Forest Lakes Phase II
Traffic Impact Analysis
PCD File No. PUDSP-18-001
(LSC #174550)
December 5, 2018

RE: Forest Lakes Phase II
El Paso County, Colorado
PCD File No. PUDSP-18-001
Traffic Impact Analysis
LSC #174550

Figure 2  
**Site Plan**

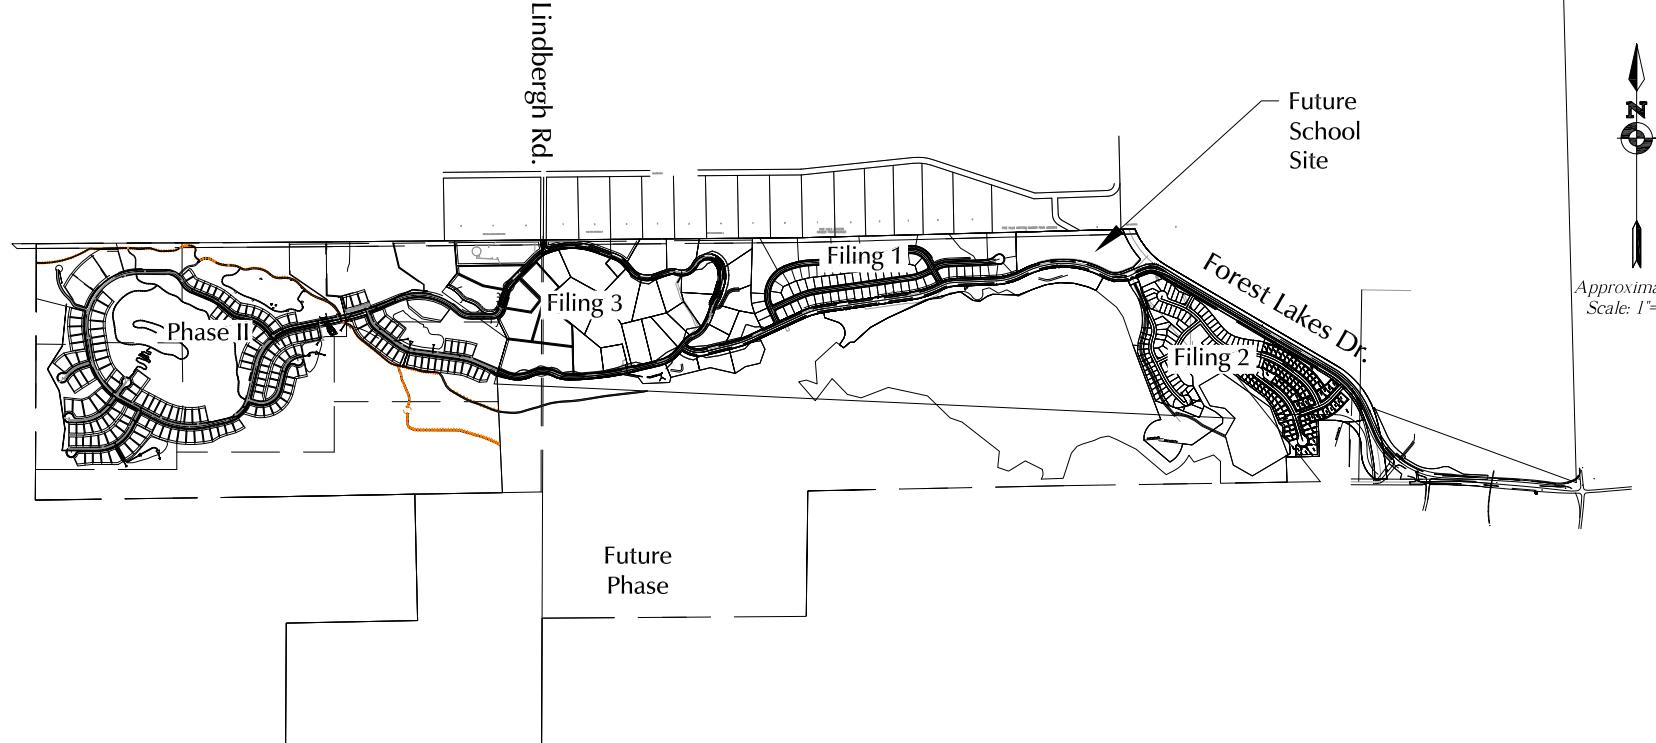
Label the future school site location listed in the trip generation table.

Figure 8

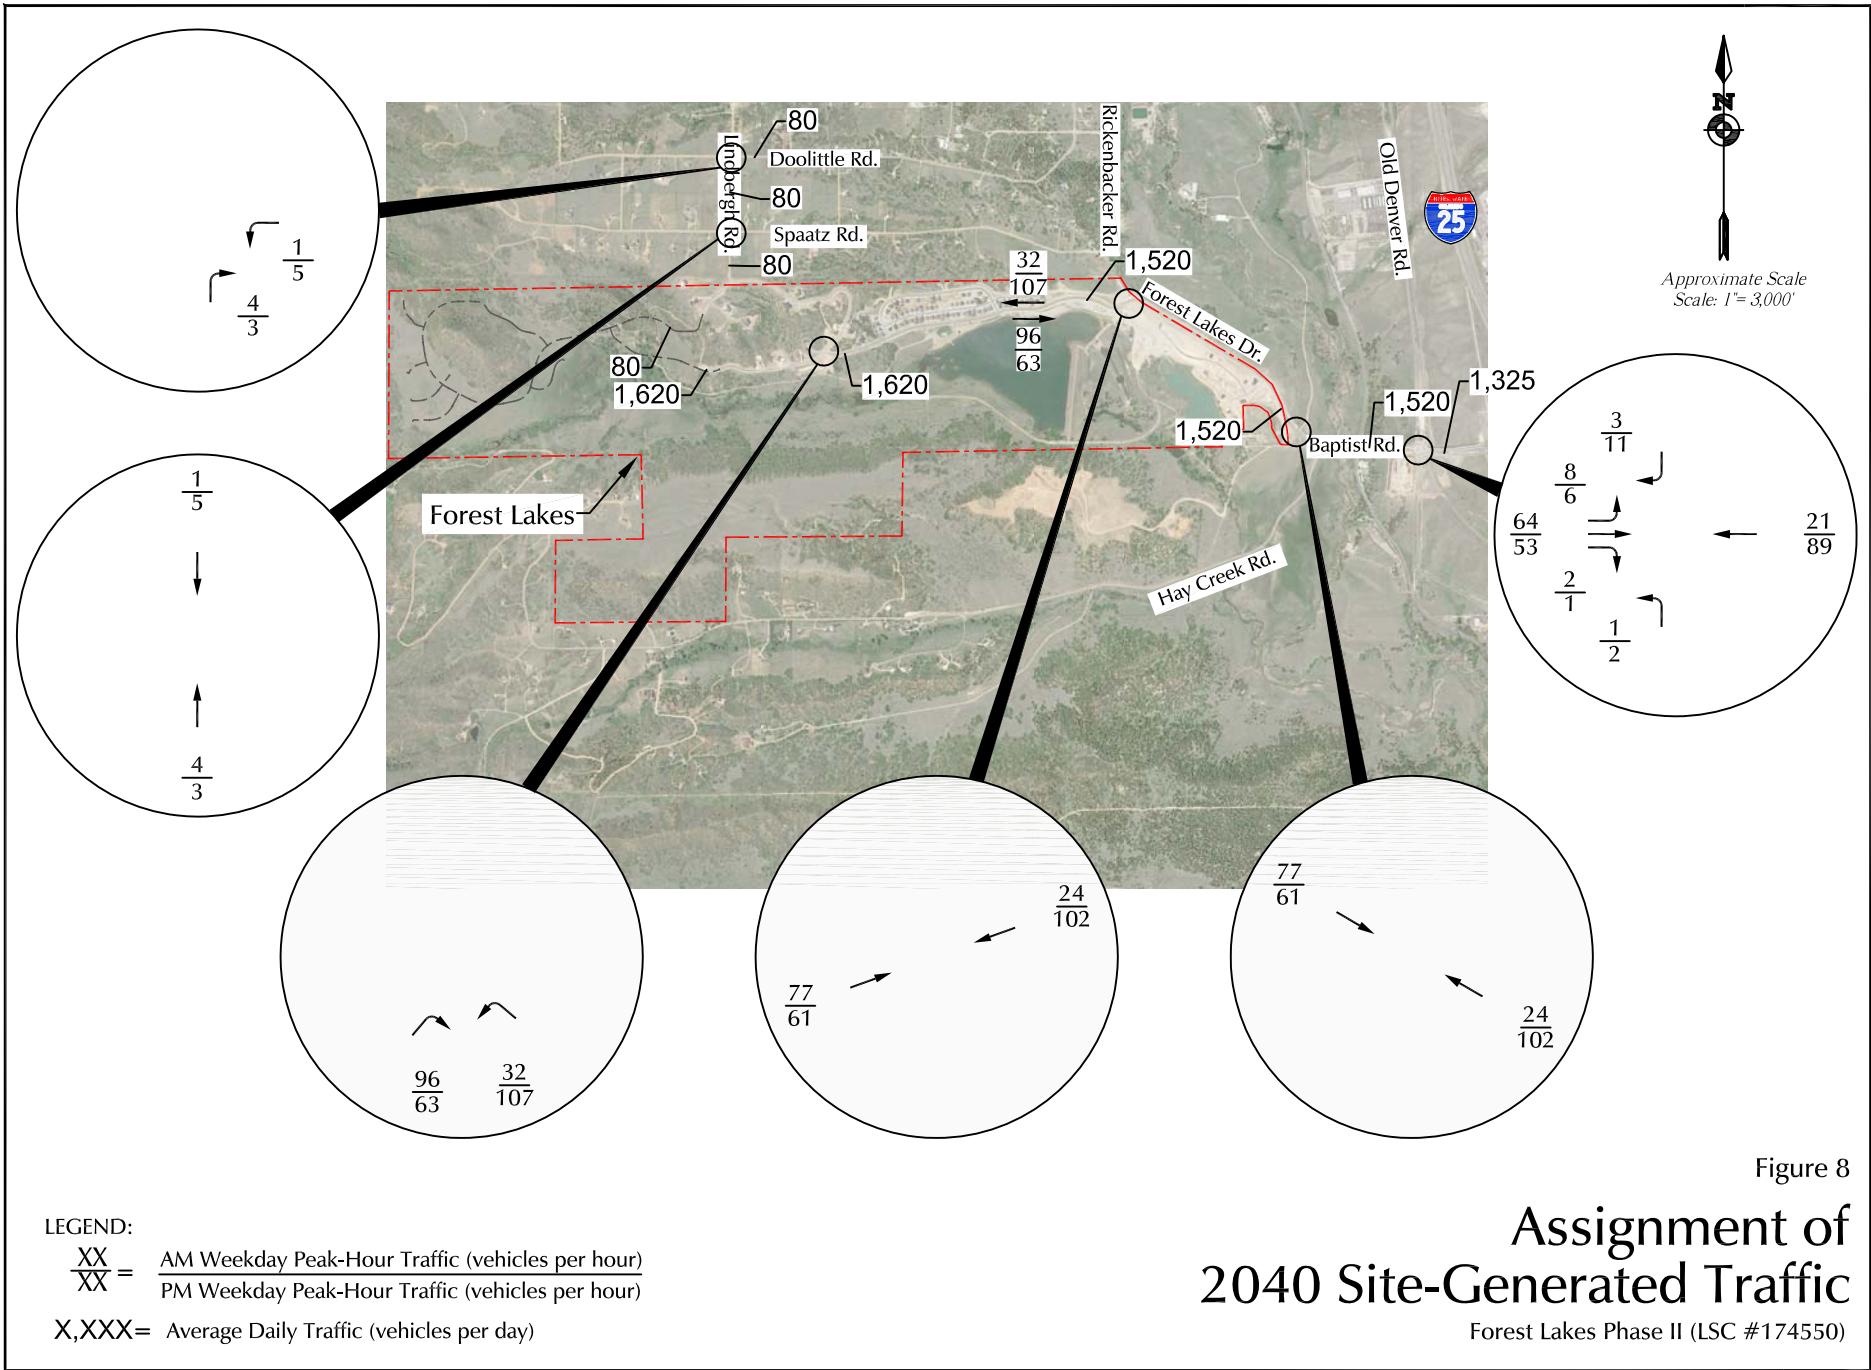
Show on the figure's

Figure 3
 Existing Traffic, Lane Geometry,
 Traffic Control and Level of Service
 Forest Lakes Phase II (LSC #174550)

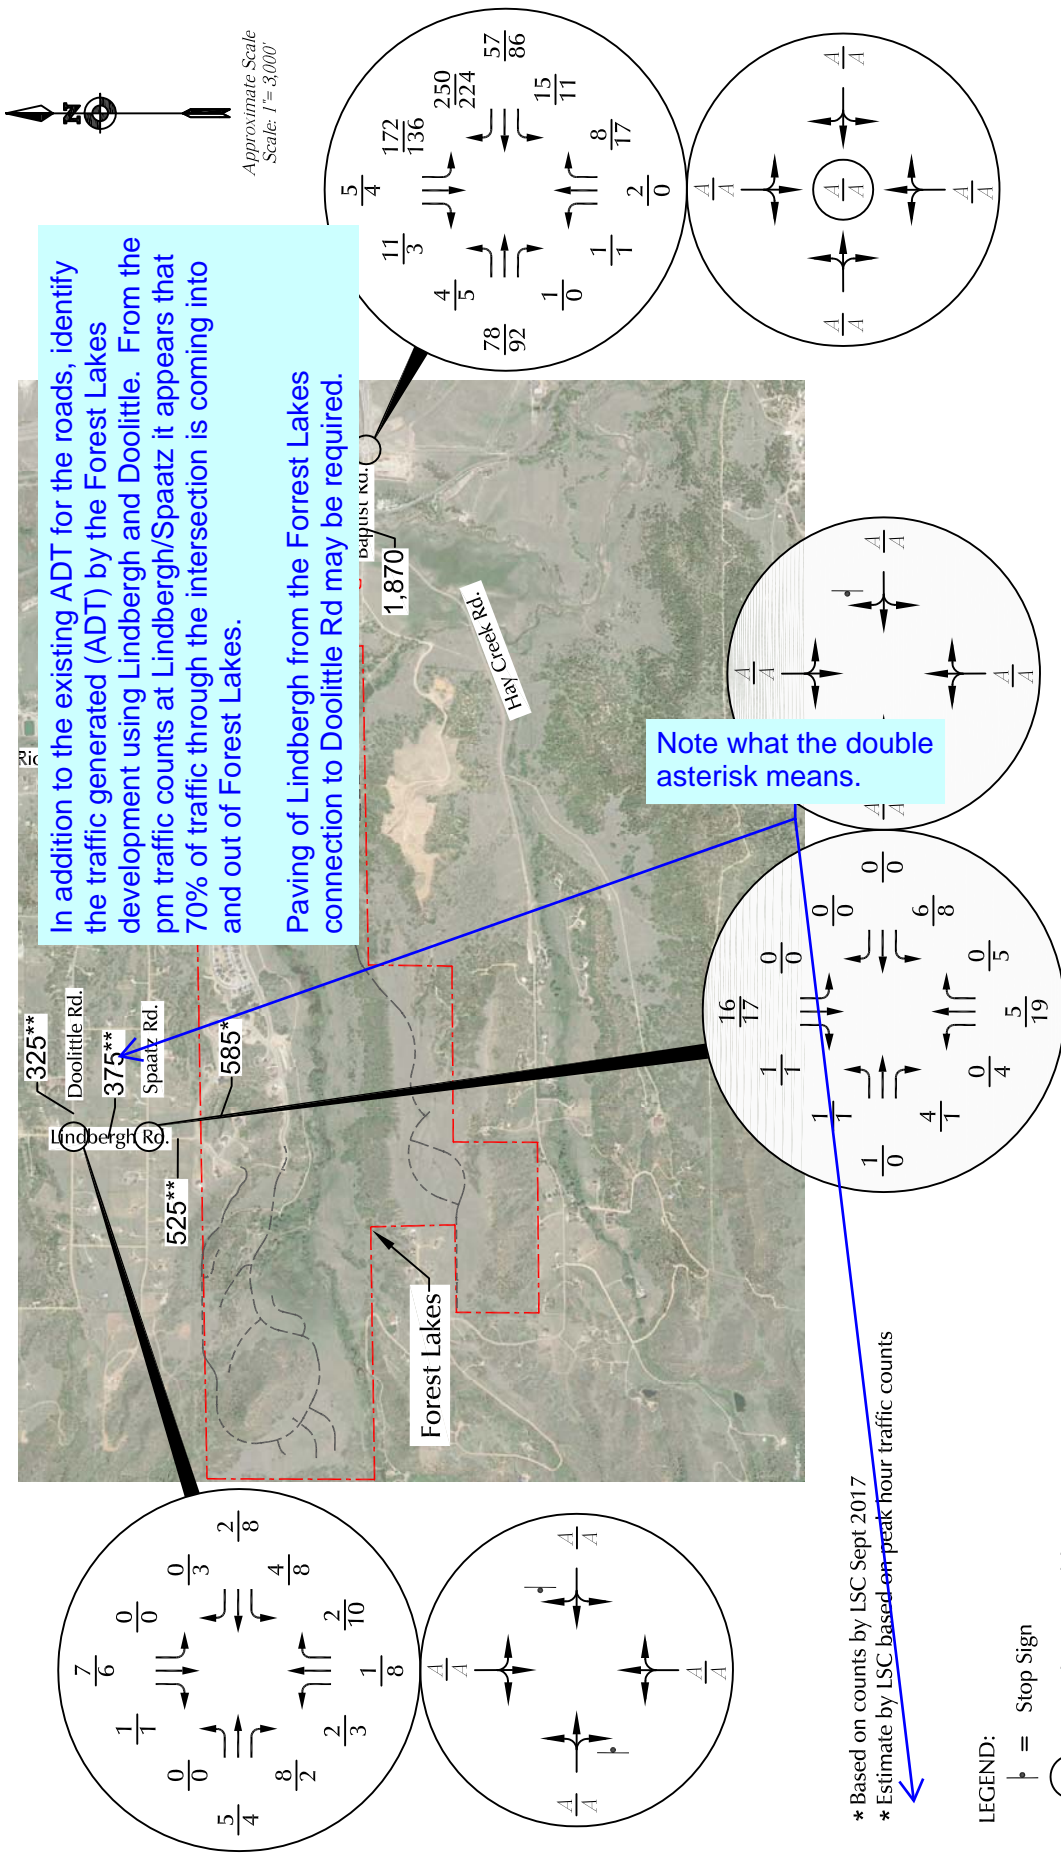
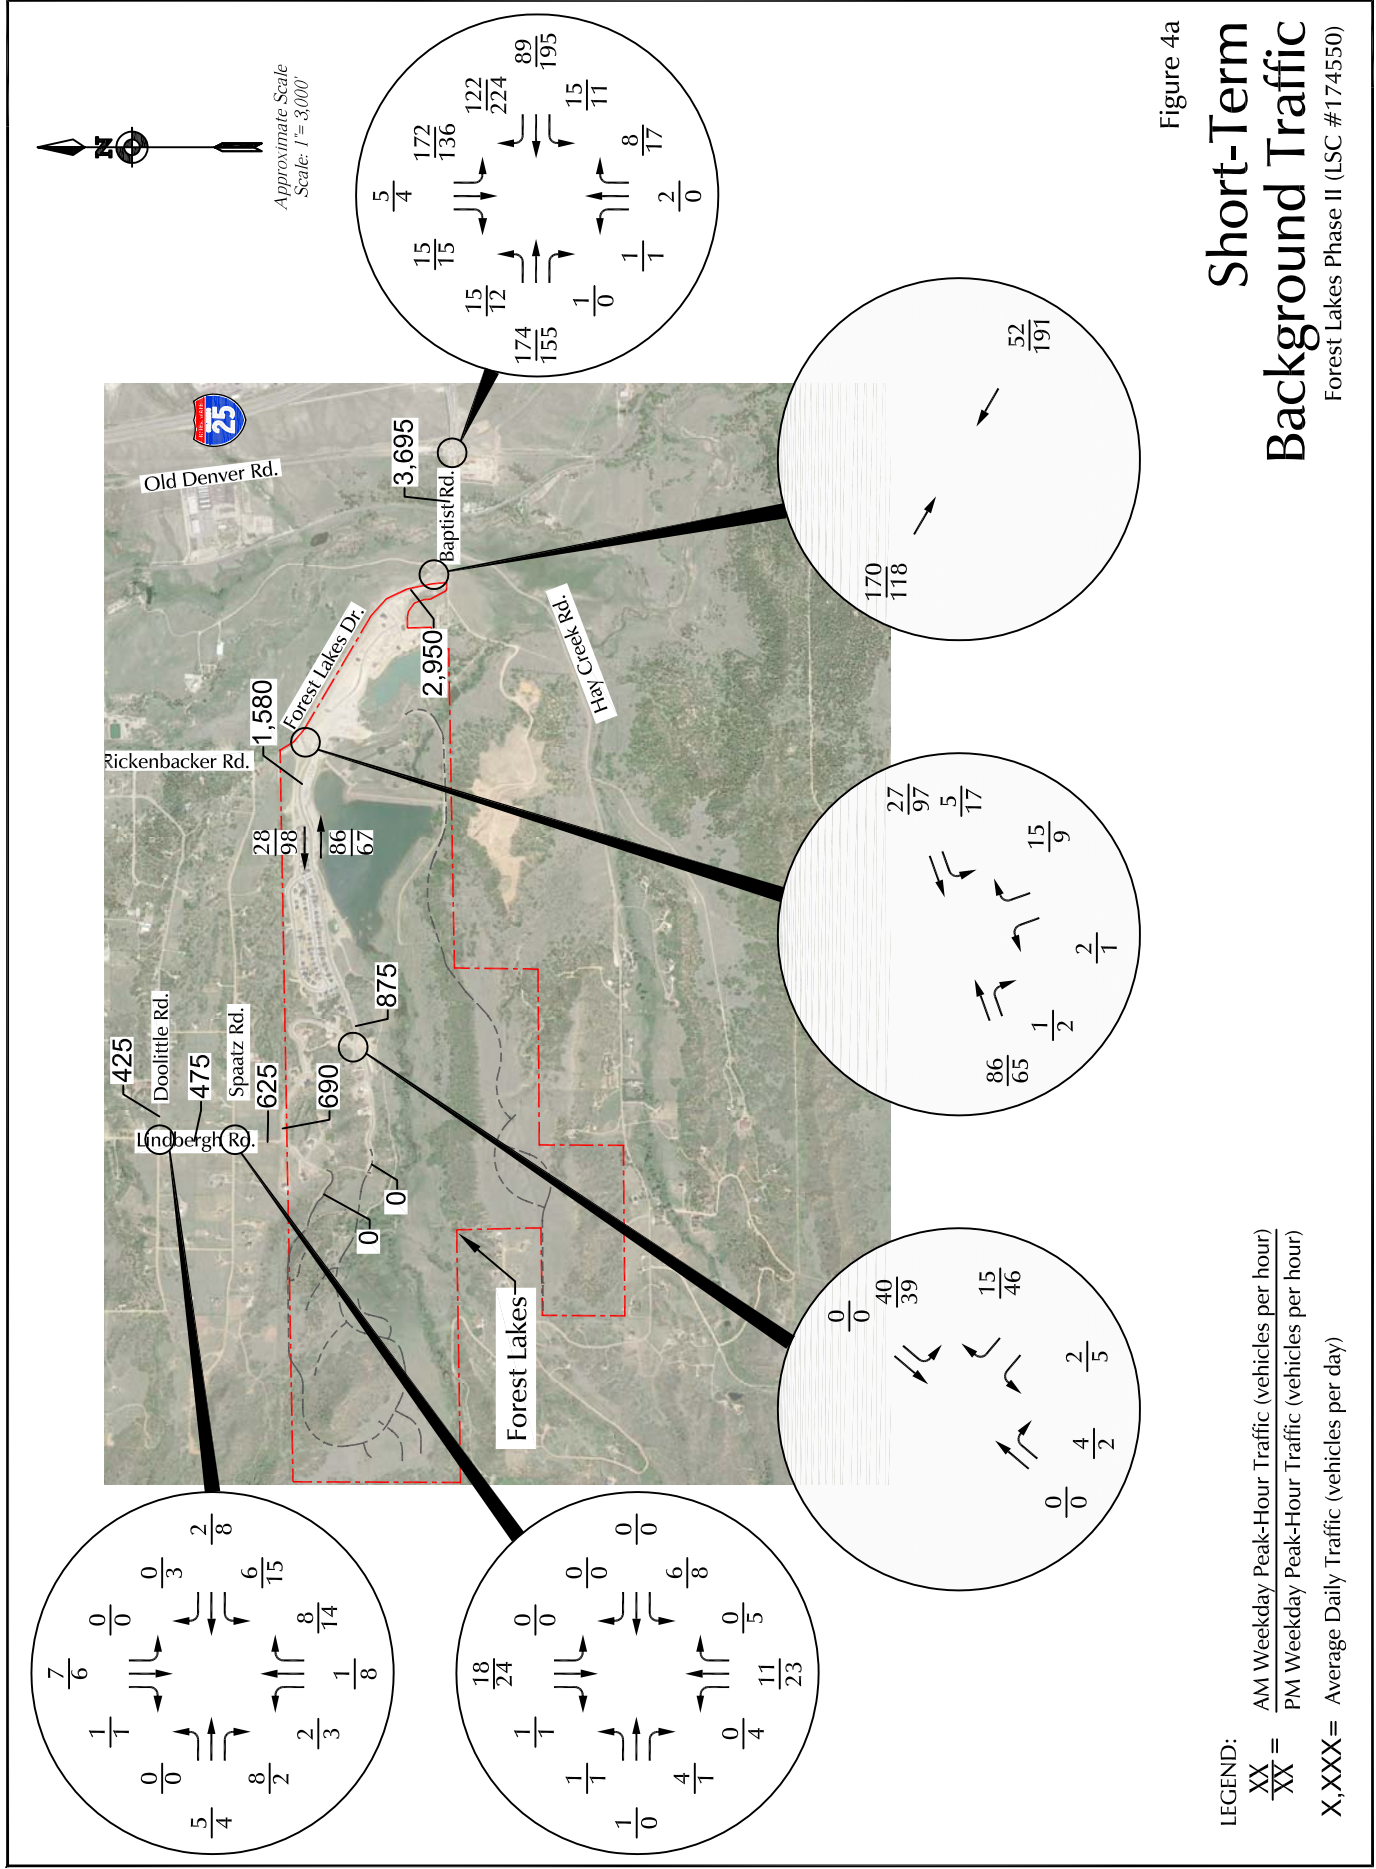
Update footnote ** to explain how the estimate was derived from the PkHr counts. (Is it a conversion factor?)

Expand the narrative regarding Lindberg. Explain the change in traffic behavior prior to and after forest lakes development. Does the original TIS include traffic counts on Lindberg prior to this access connection?
